Planning Application Ref: FP/96/17/T

Location : 5 Admiralty Road, Felpham

Description of works: Fell 1 No Bay tree

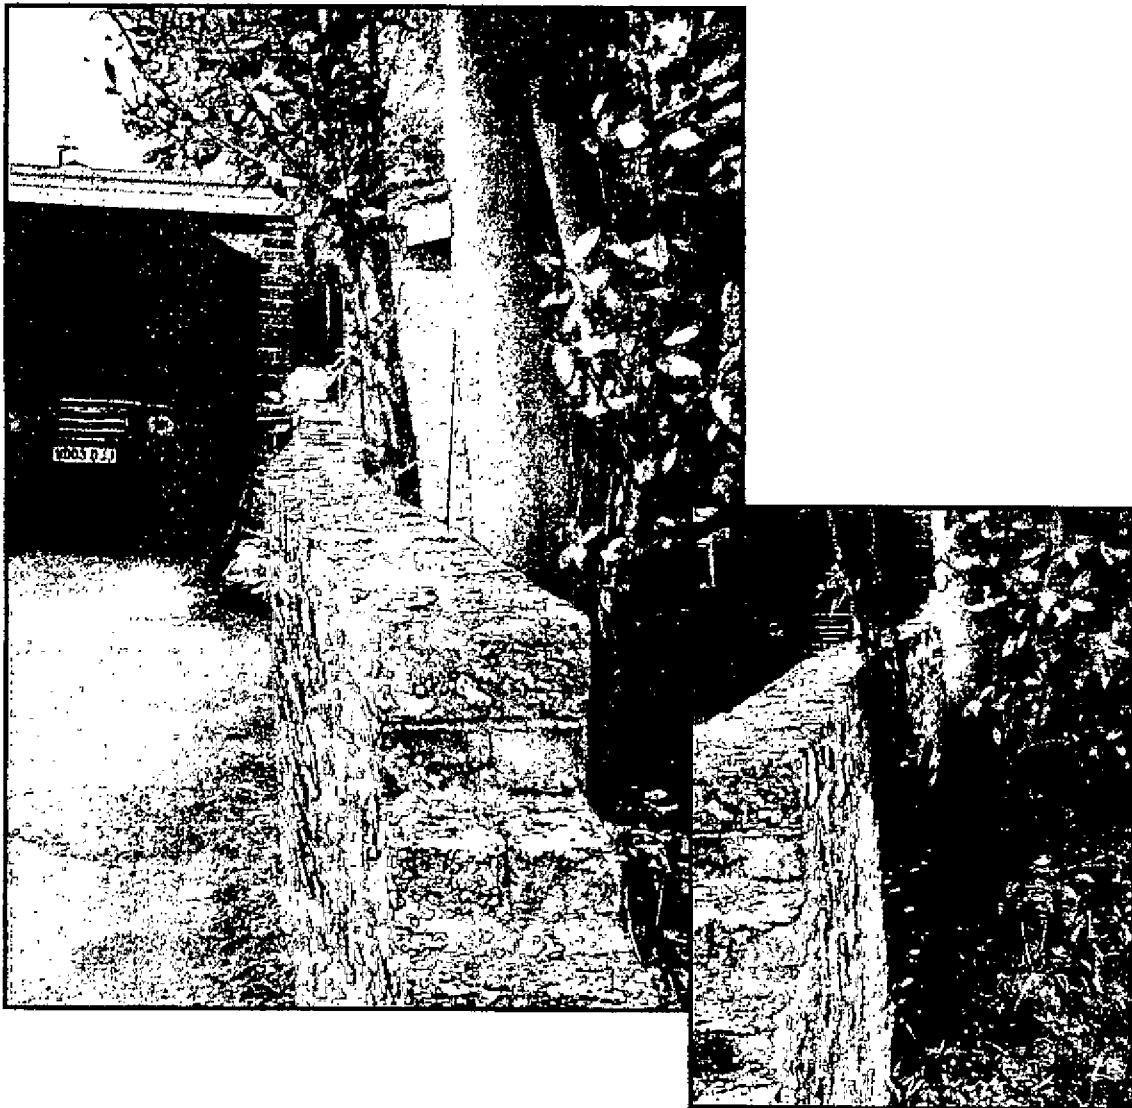
- This tree is multi-stemmed at ground level with a significant flare to the basal area and direct contact with the wall which has pushed the wall out of alignment.
- This will continue year on year and the normal course of action would be to insist on a reinforced lintel to span the gap when the wall is rebuilt but there is no space to achieve this and the ground clearance would have to be about 1m.
- Added to which this tree contains dieback and has been poorly pruned in the past which has left it unbalanced and of poor shape and form overall.

- The wall needs to be repaired for safety reasons.
- This cannot be done whilst the tree remains at this location.
- There are no suitable pruning or building solutions applicable in this instance.

- I recommend **APPROVAL** of this application on the grounds that this is a tree of low value and there are no pruning or building solutions applicable in this instance.
- There will be a requirement to plant a new tree in this front garden but not at the same location – but rather one that is acceptable to the owners.
- This is to be of **Light Standard Nursery Stock** – a tree of 6ft to 8ft in height and 8cm to 10cm in circumference staked and tied on a short staking system- to be planted within 12 months of the original trees removal.
- It is to be one of the following species:-
